CITY OF ALBUQUERQUE
PLANNING DEPARTMENT
DEVELOPMENT REVIEW BOARD

Project# 1004772

13DRB-70693 SITE DEVELOPMENT PLAN FOR BUILDING PERMIT

ISAACSON & ARFMAN PA agents for APPLE INVESTORS GROUP request the referenced/ above action for Lot 20, Block 18, Tract A. Unit B, **NORTH ALBUQUERQUE ACRES** & Tract B, **HOLLY PLACE** zoned SU-2/M-1 OR SU-2/RC, located on the south side of HOLLY AVE NE between SAN PEDRO DR NE and I-25 containing approximately 1.5709 acres. (C-18)

project title
CP-001 SITE DEVELOPMENT PLAN FOR BUILDING PERMIT drawing number

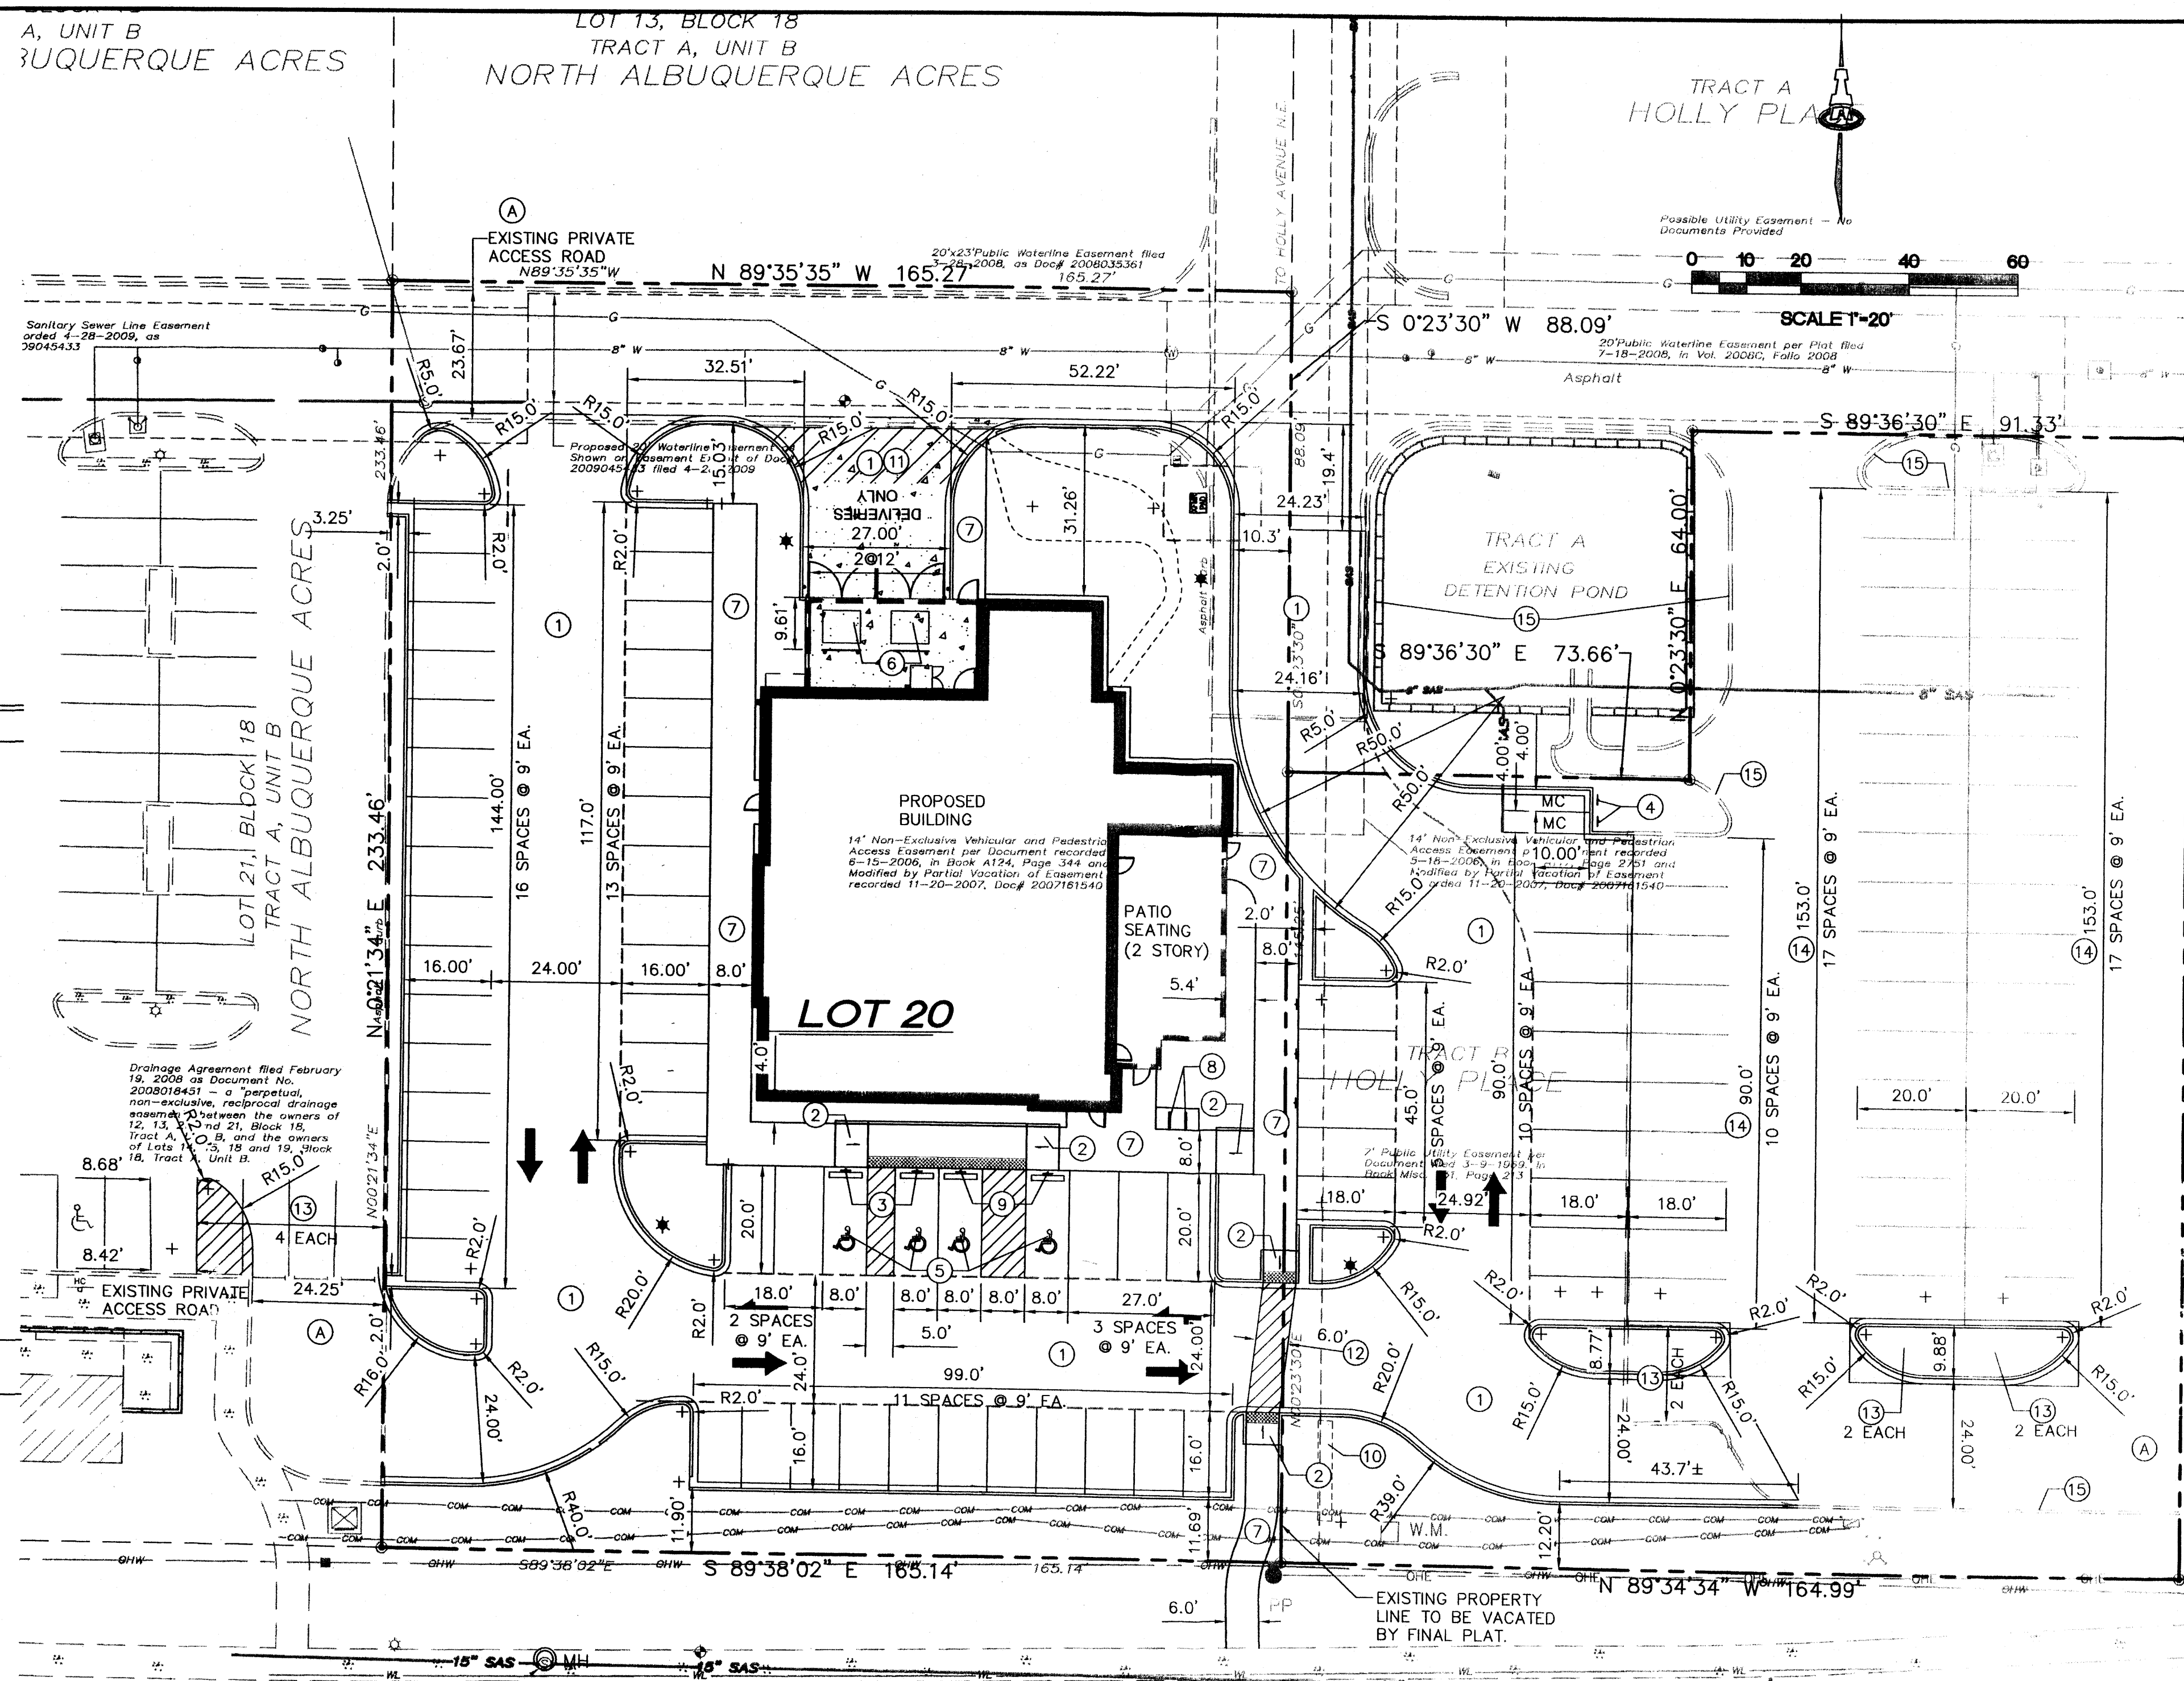
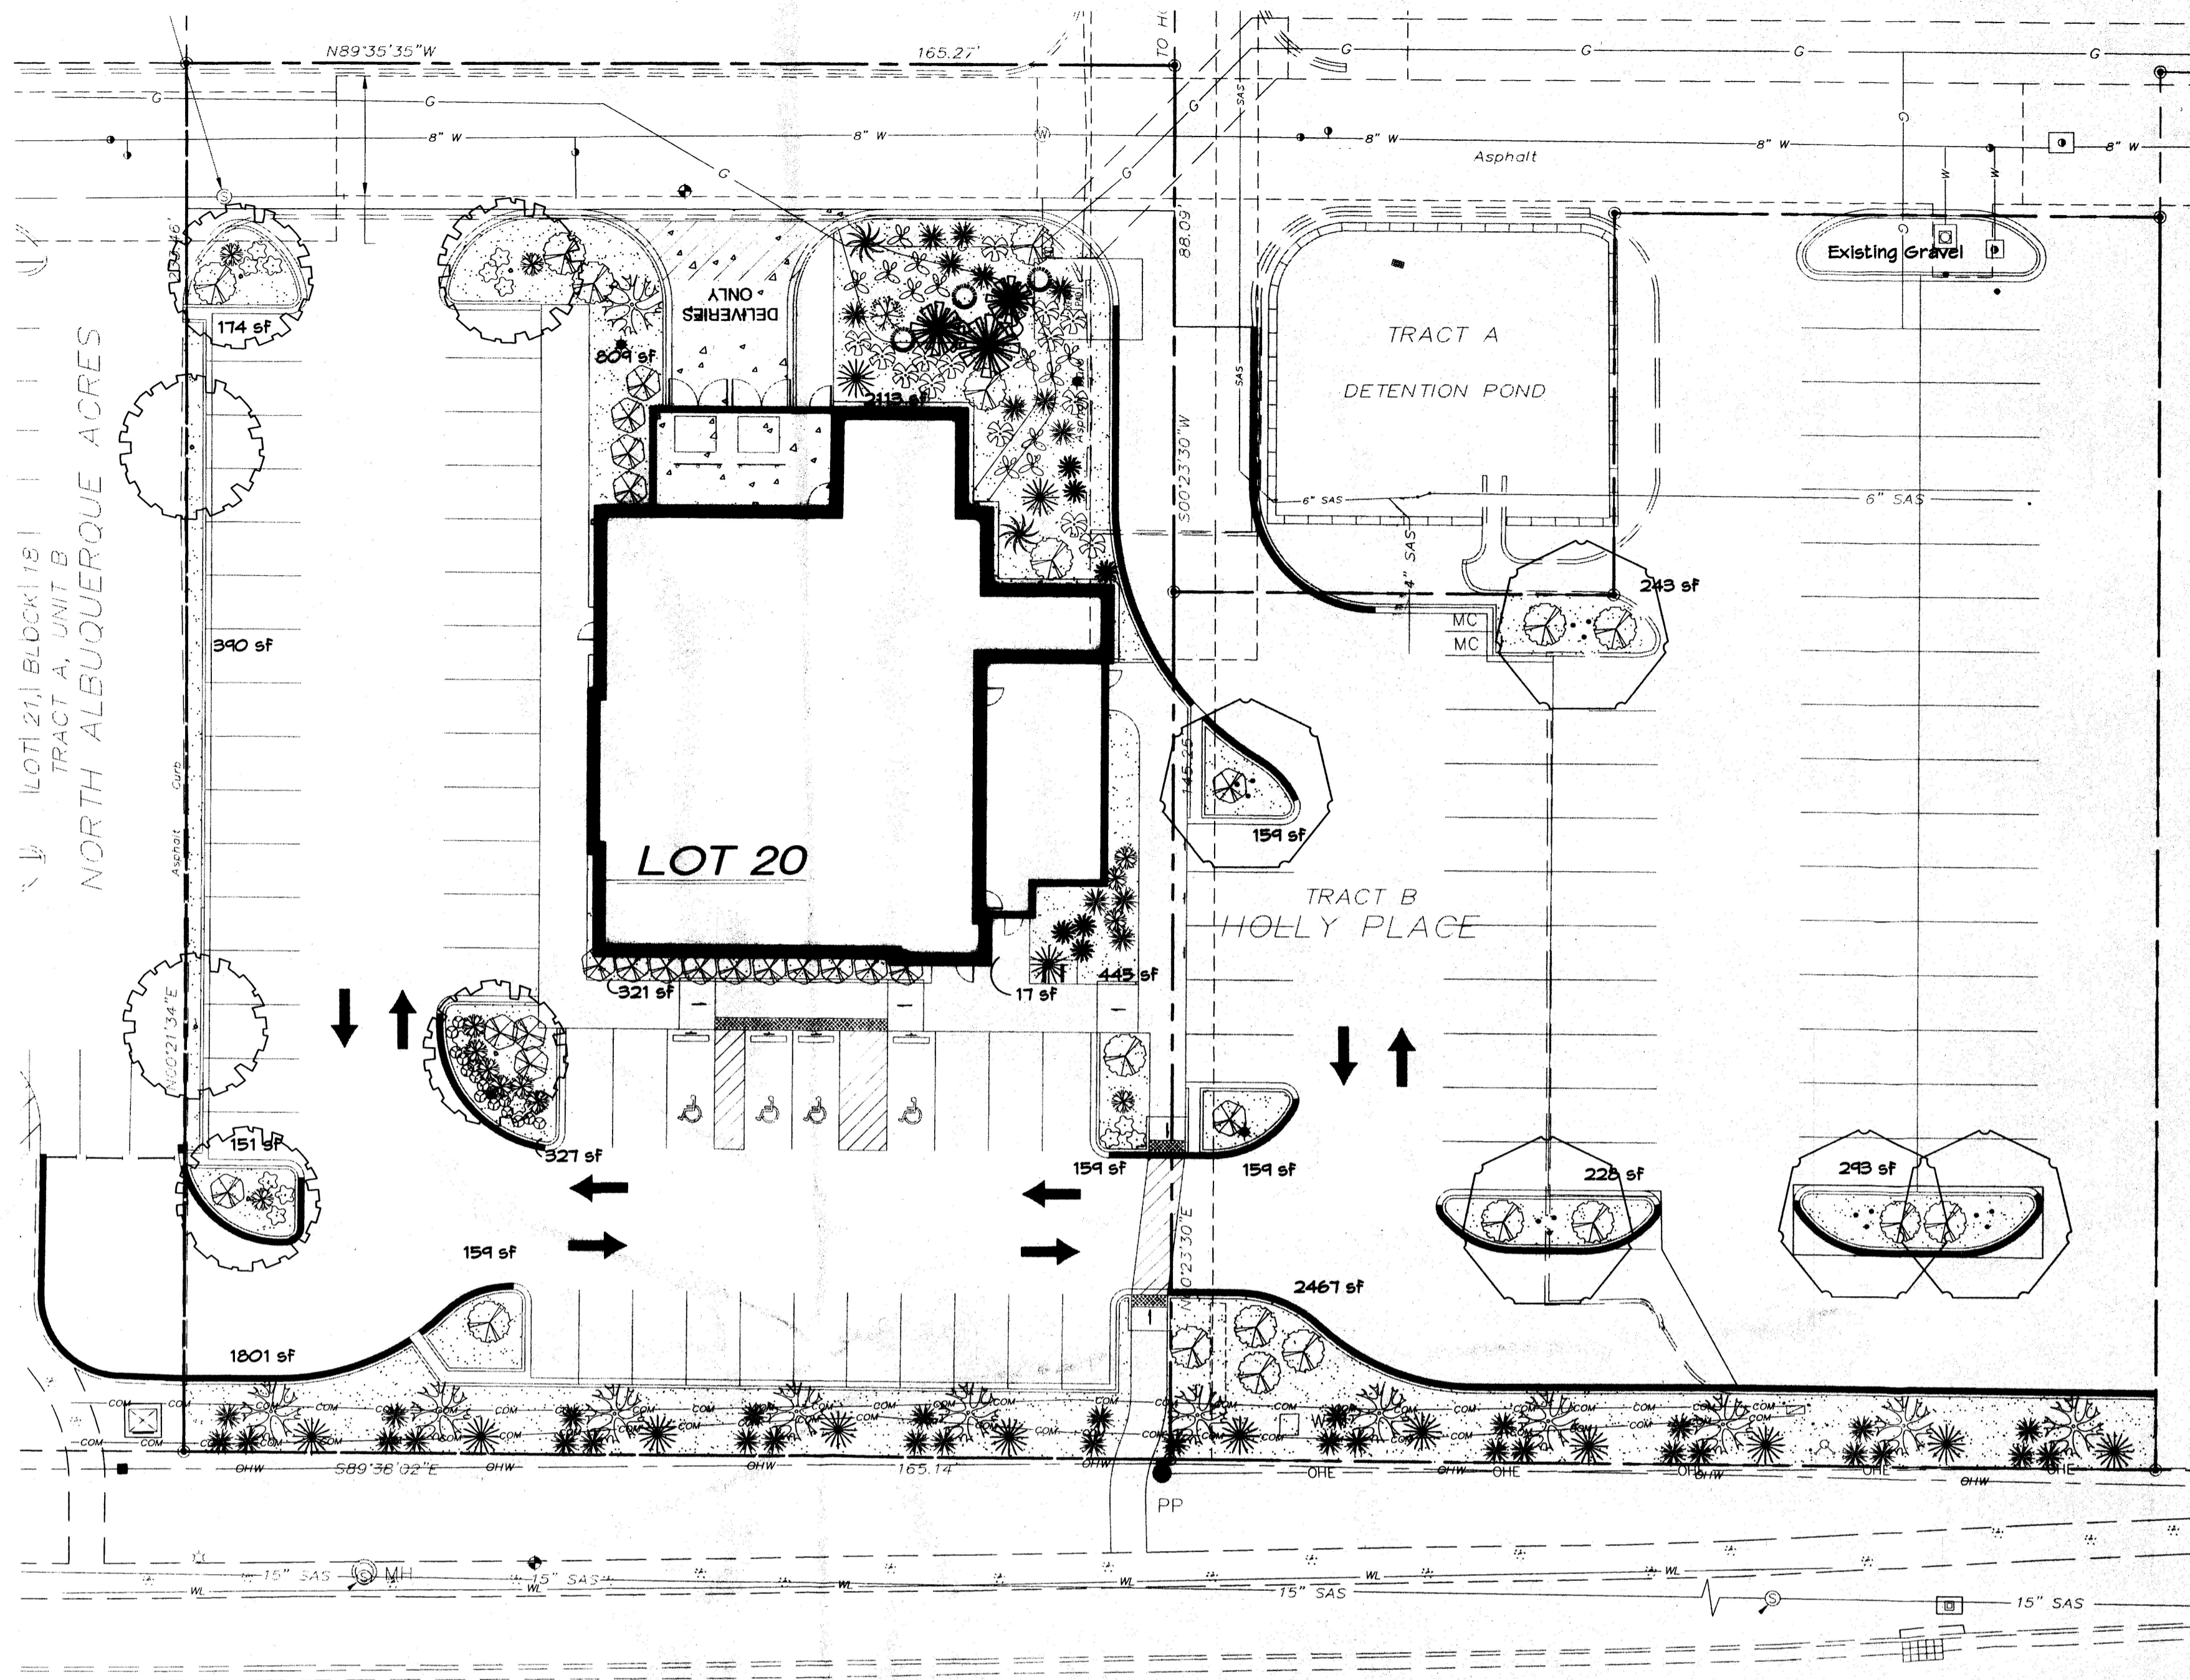
AMAFCA No comments provided.
COG No comments provided.
TRANSIT No comments
ZONING ENFORCEMENT The pedestrian connection is striped. It should be differentiated from the surrounding pavement by being pavers or etched concrete or bricks etc. page 32 e2 , as per the north I 25 plan. 29 parking spaces are noted as being required, no analysis is provided. Applebees usually has a full service bar and parking is 1 space per 3 of fire occupancy.
NEIGHBORHOOD COORDINATION Affected NA/HOA's: No Neighborhood and/or Homeowner Associations
APS This will have no adverse impacts to the APS district.
POLICE DEPARTMENT This project is in the Northeast Area Command. - Proposed exterior lighting appear to be in conflict with planned landscaping, particularly tree plantings. Once trees become mature, they will eventually reduce the amount of illumination provided by the pole lights. Recommend eliminating tree plantings immediately adjacent to all pole lights in an around the parking lot. - Bush variety landscaping could reduce natural surveillance in the parking lot. Suggest maintaining site lines in all parking lots, walkways, common areas and building walk-ups. - Recommend the installation of a video surveillance camera system. Cameras should be positioned to view all parking areas, walkways, common areas, building entrances and walk-up areas. Each camera should be monitored and recorded for real-time and historical use.

<p>PARKS AND RECREATION No comments.</p>
<p>ABCWUA</p>
<p>PLANNING DEPARTMENT All plan sheets need to be consistent (ref Landscape Plan, SW corner). Restaurant parking calculations are needed. Refer to Site Plan for Subdivision this project # for pedestrian connections, particularly thru Tract B. Refer to comments from Zoning Enforcement regarding compliance with the Zoning Code and the North I-25 Sector Development Plan, plus any public hearing comments regarding proposed plan.</p>
